Memorandum

To:	Norine Allerdice	Date:	February 28, 2023
From:	April Ng		
Project:	Butenwieser/Wiley Residence 6838 96 th Ave SE Mercer Island, WA 98040 King County APN 302405-9010	File No:	2205-199
Subject:	Building Permit Review SUB3 Response

The comments are restated below, followed by responses. Updated drawings have been clouded with Revision 3: 2/23/23 Building Permit Resubmittal 3.

GRADING PLAN

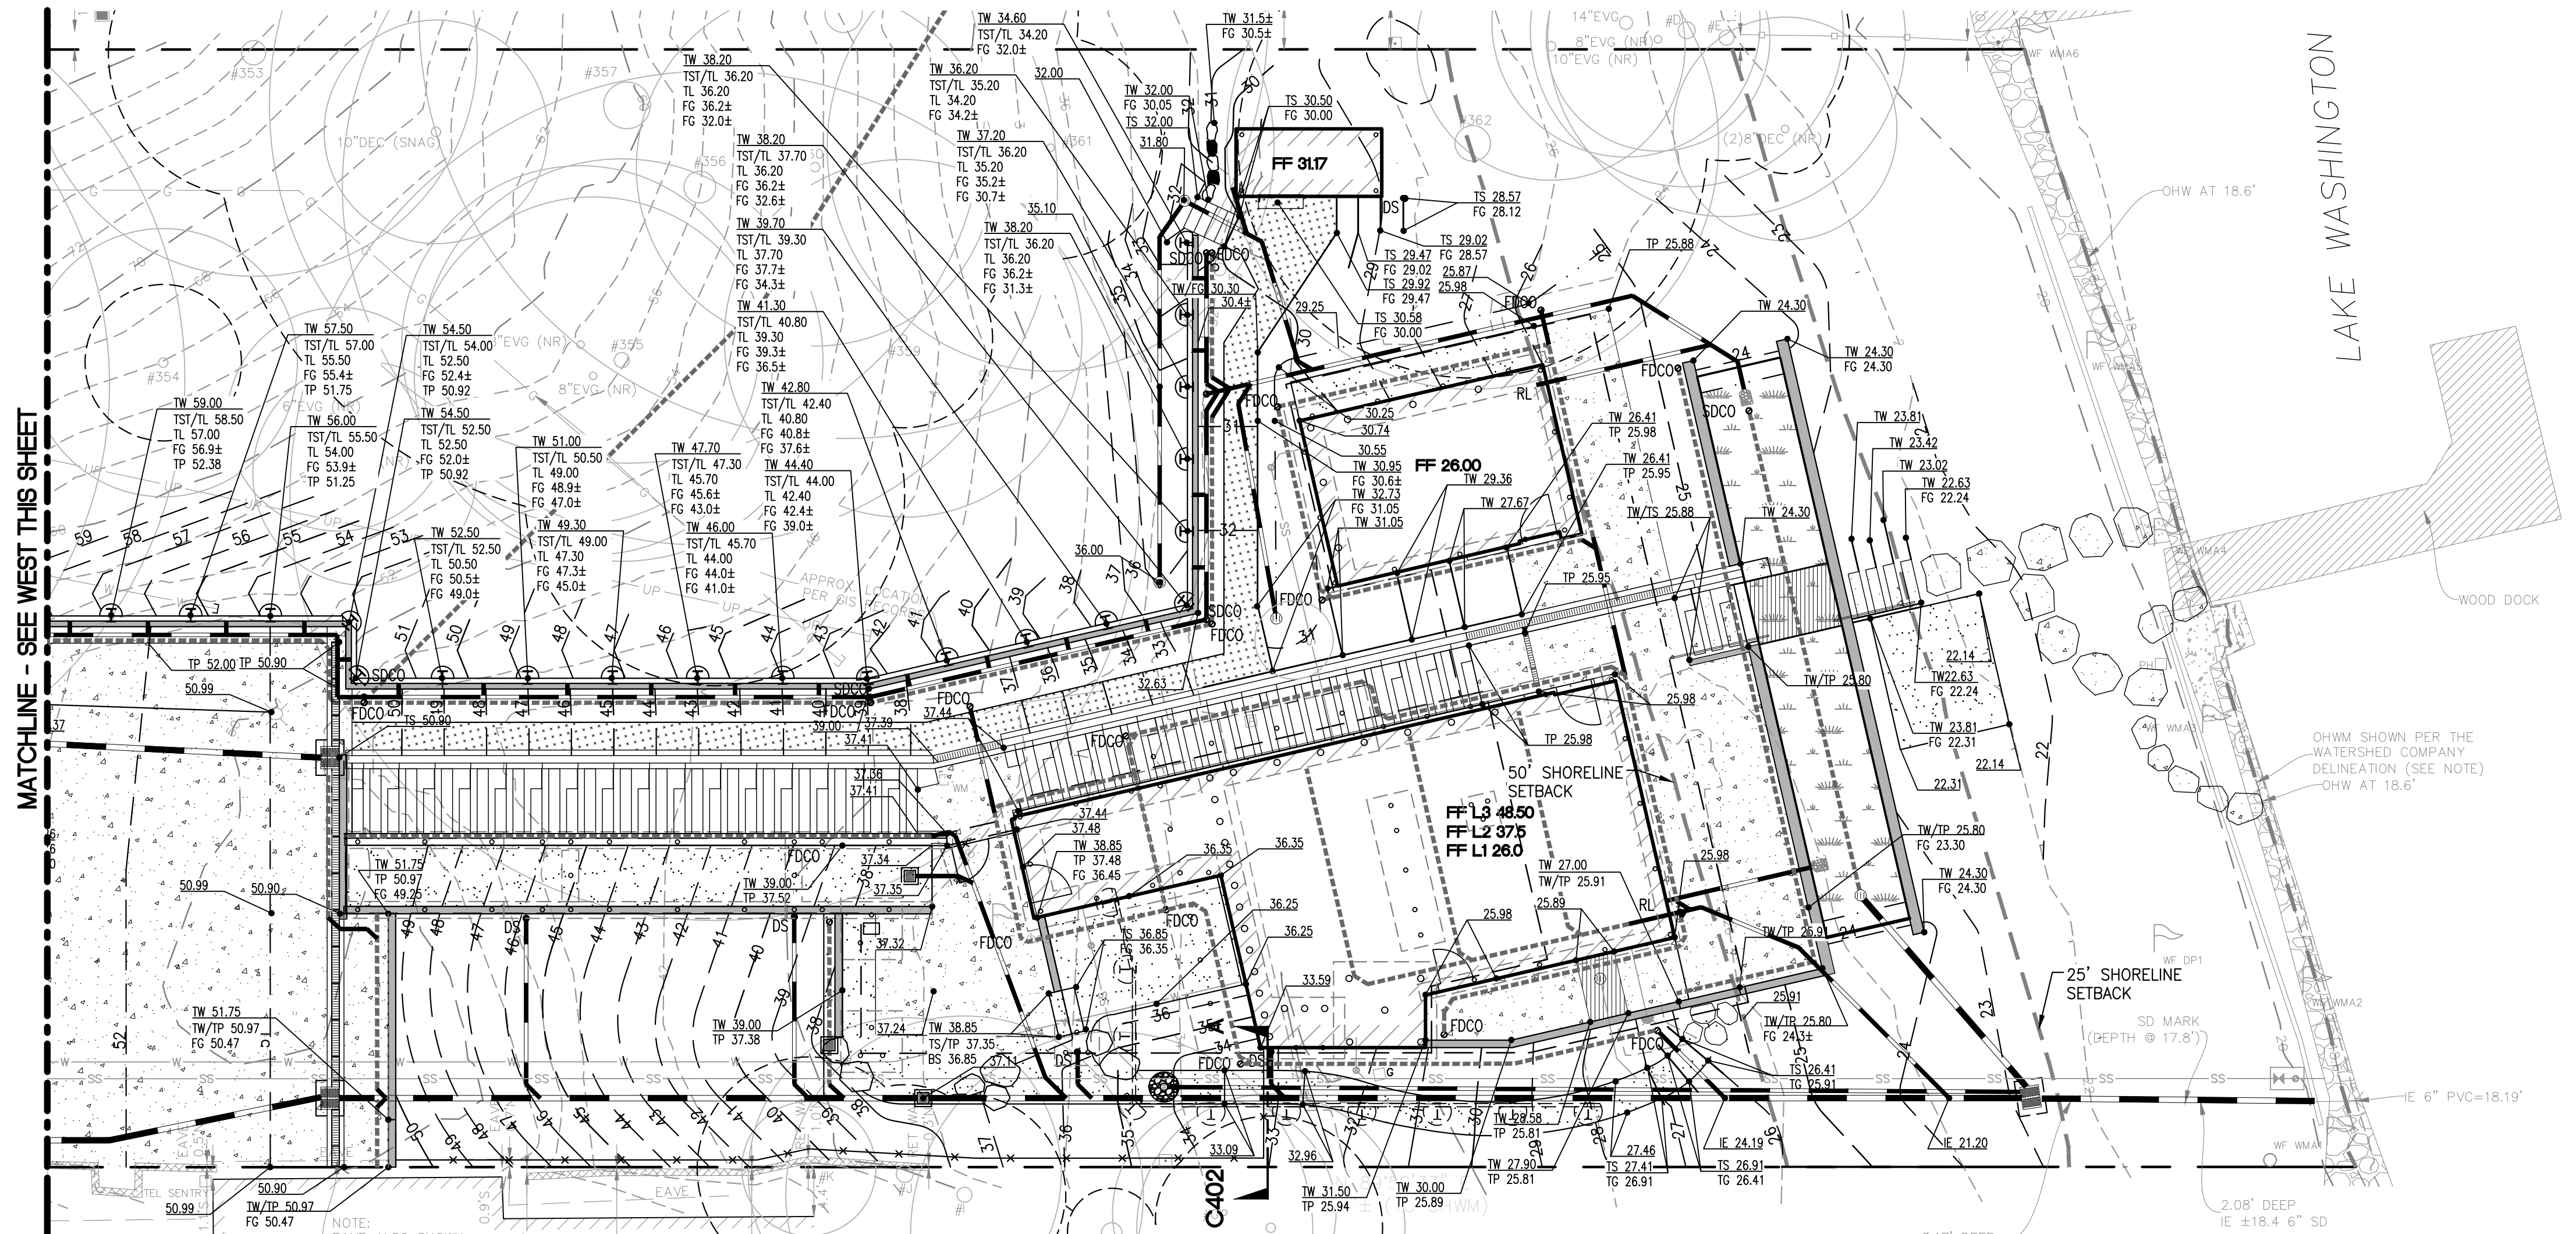
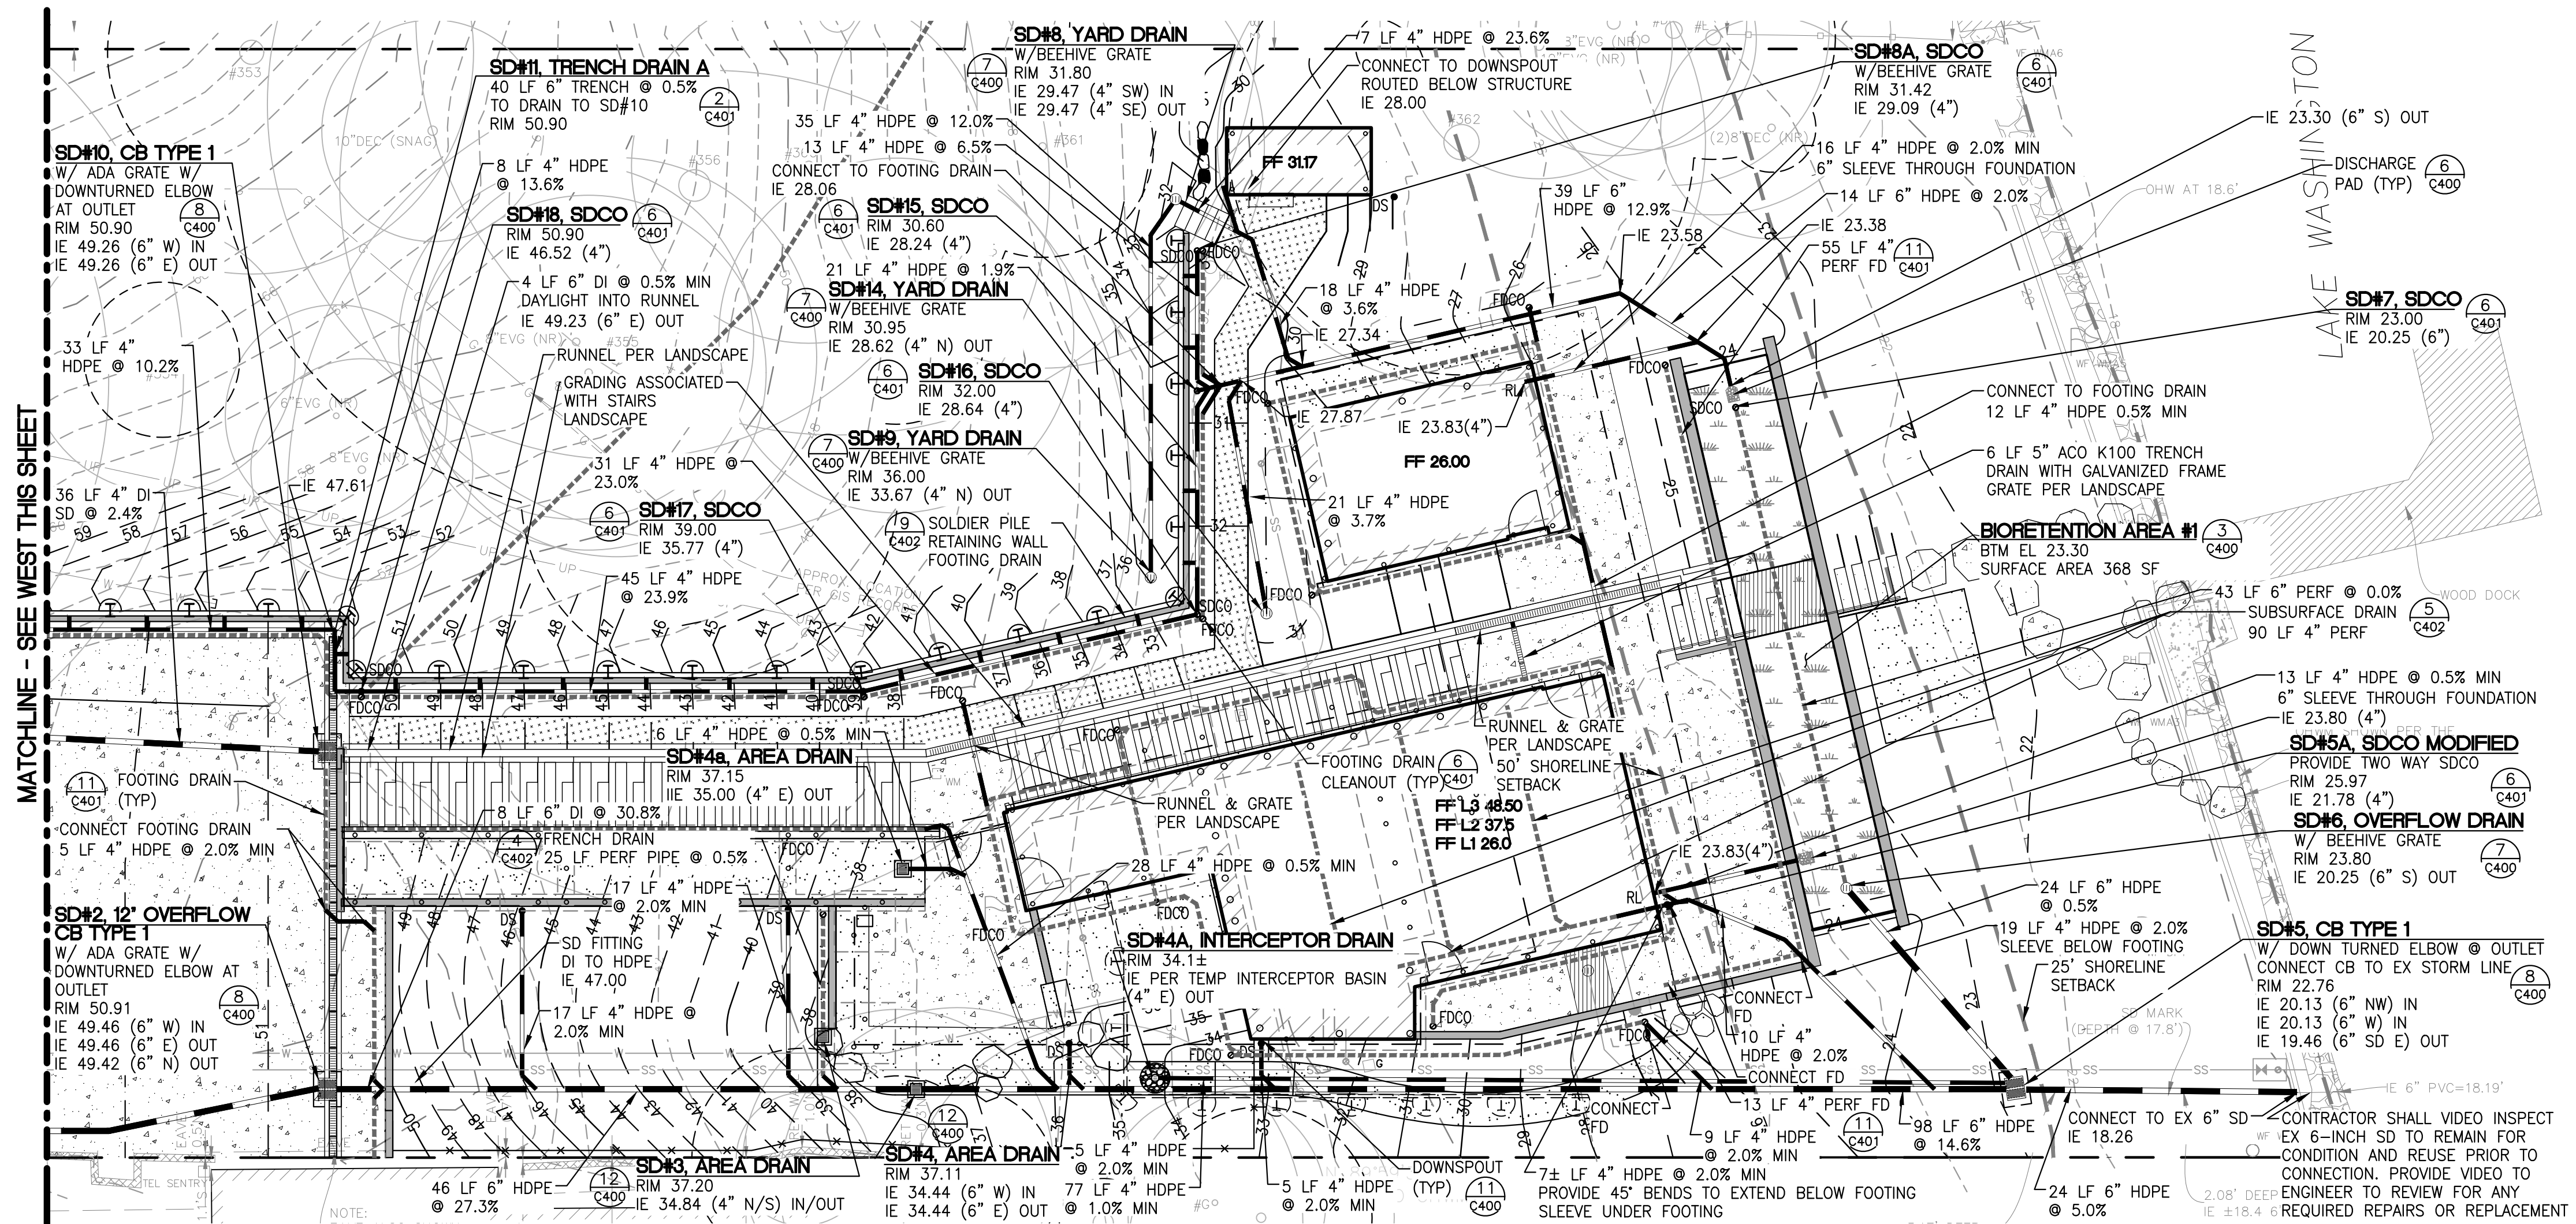
C101B Is this a new rockery wall to replace the existing rockery in ROW? Can you provide more details such as a section, elevations,	The existing rockery is proposed to be reconstructed following the installation of the new fire/water service. Additional detailing has been provided on C200A, C300 and 1/C402. Per coordination with the Geotechnical	C200A, C300, 1/C402

drainage behind the wall (if there is a drainage pipe)?	Engineer, no drainage pipe is required behind the wall due to the limited height. Free draining material is proposed behind the wall and any limited sub surface water will seep through the rockery.	
---	---	--
